Town & Country Planning Act 1990 (as amended)
Town & Country Planning (Tree Preservation) (England) Regulations 2012

Application for Works to Trees(s) subject to a Tree Preservation Order(TPO)

Development: Reduce branch of 1 No. Corsican pine to 3.5m.
Location: 92 The Fairway Aldwick PO21 4EW

Corsican Pine 92 The Fairway

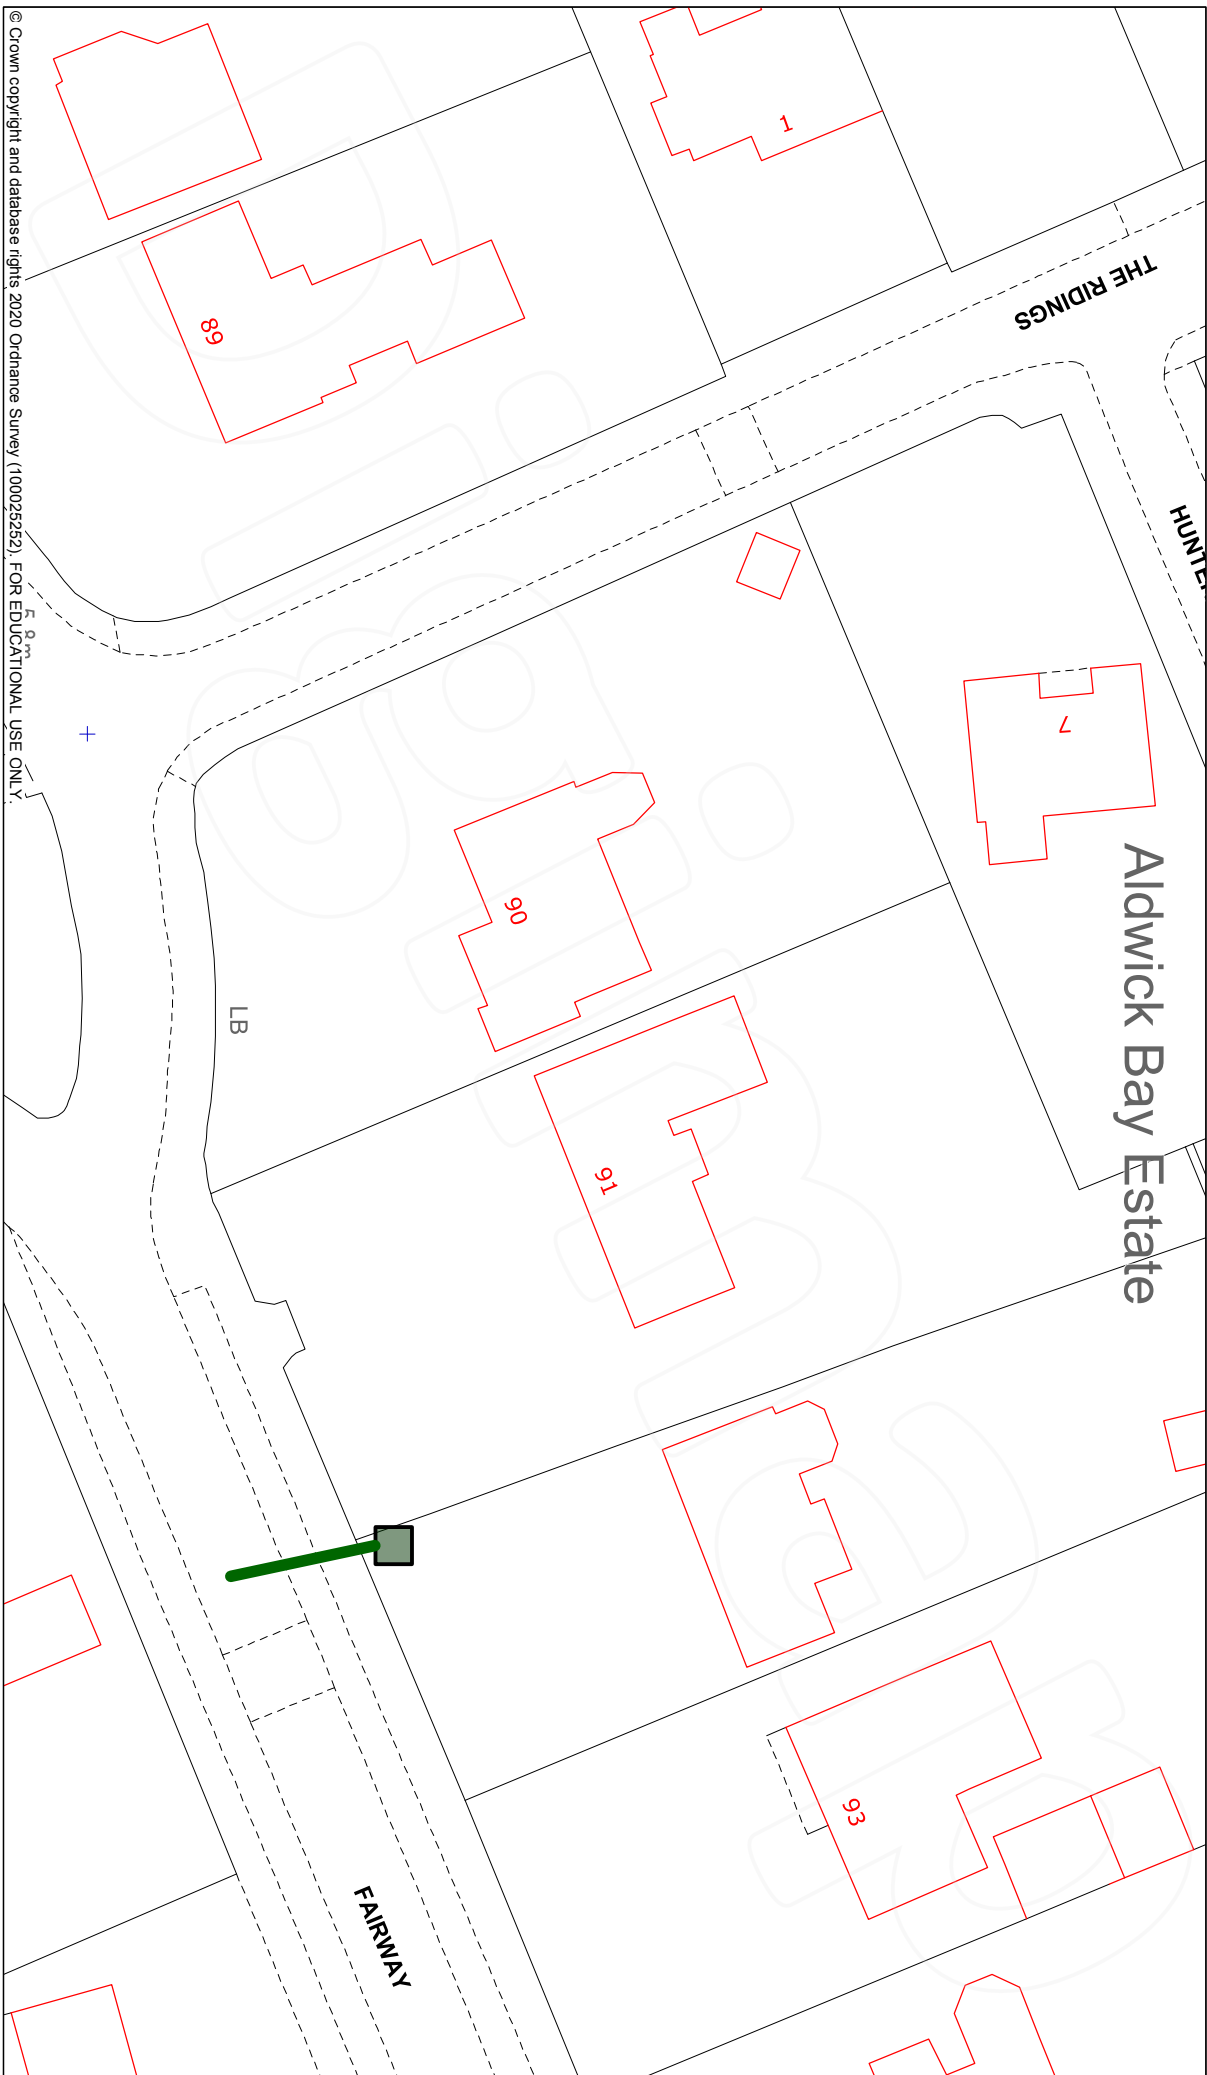
Please clearly identify the branch which you propose to reduce i.e by drawing an arrow to the branch.
